18 May 2017

Department of Planning and
Environment
GPO Box 39
Sydney NSW 2001

Re: Major Project – Santos Narrabri Gas Project SSD 6456 – Narrabri Shire Council Submission

Figure 12-1 Treated water management options

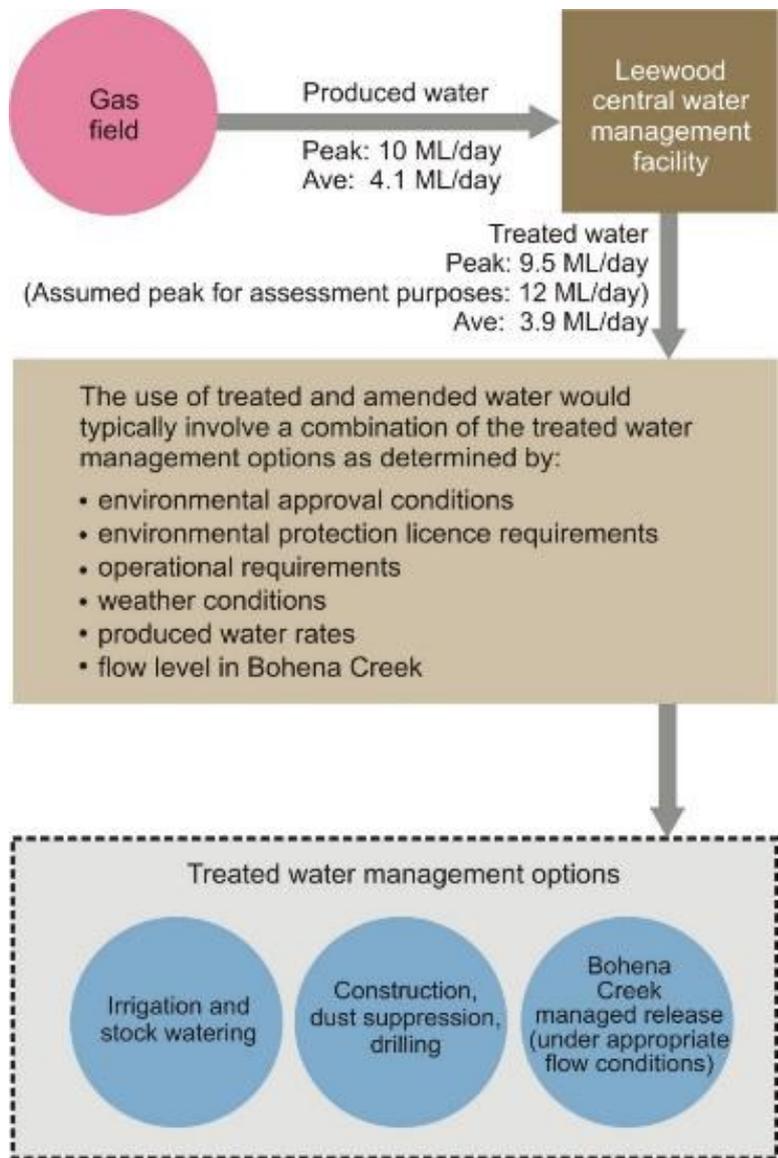
Once the water has been treated, options have been presented for the beneficial reuse. These options include irrigation, dust suppression, construction and drilling. It has also been proposed to discharge the produced water into Bohena Creek. Produced water will only be discharged into Bohena Creek during periods where flows are above 100 megalitres (ML) per day measured at the Newell Highway gauging station. This threshold limit has been adopted in an attempt to dilute any contaminants present in the produced water that will be released into Bohena Creek.

1. During periods where flows are less than this threshold limit of 100 megalitres (ML), but beneficial reuse (such as dust suppression or irrigation) is not an option due to inclement weather, how will the storage ponds water volume be managed to prevent overtopping? How have the ponds been sized? Have they been sized appropriately?
2. There is not a thorough discussion of hydrocarbons or metals in produced or amended water.
3. In Chapter 12, *Section 12.3.3 Dust Suppression, Construction and Drilling* Table 12-3 indicates that treated water to be used for dust suppression is likely to exceed the 84th percentile of the Bohena Creek baseline water quality for:
 - Electrical conductivity;
 - Sodium; and
 - Boron.

1. Council seeks clarification on what measures will be taken if produced water is unable to be released into Bohena Creek or to be utilised for beneficial reuse but storage ponds are nearing or at capacity to prevent spilling?

Figure 12-8 Bohena Creek monitoring and response measures

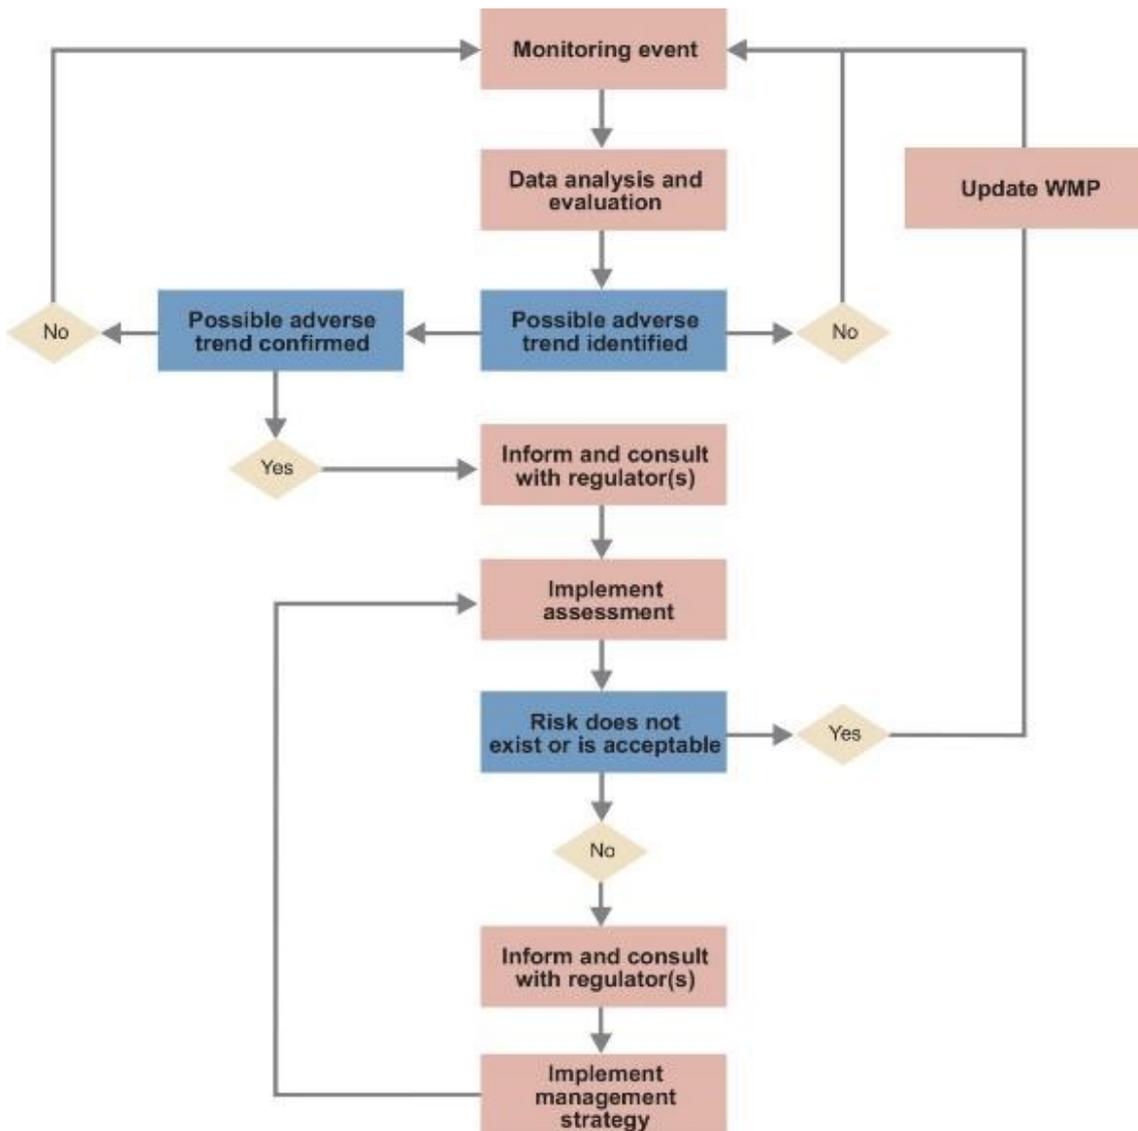
4. The gauging station at the Newell Highway is approximately 5 kilometres downstream (via the creek bed) of the proposed discharge area. Concern has been expressed that two tributaries (Killen Creek, Sawpit Creek) feed Bohena Creek but enter the creek downstream of the discharge area. The gauging station, further downstream than the tributaries input, may register sufficient flow, however, Bohena Creek, at the discharge area, may not have sufficient flow due to the downstream confluence of the aforementioned creeks to provide sufficient dilution.

4. Council seek confirmation that the gauging station located at the Newell Highway is representative of the upstream flow. Depending on inputs from Killen Creek and Sawpit Creek, 100ML may be registered at the gauging station but may not be representative of the discharge site. If it is not deemed to be

representative, it is proposed that a gauging station be installed closer to the discharge area or other actions are proposed that build a higher target flow into the process.
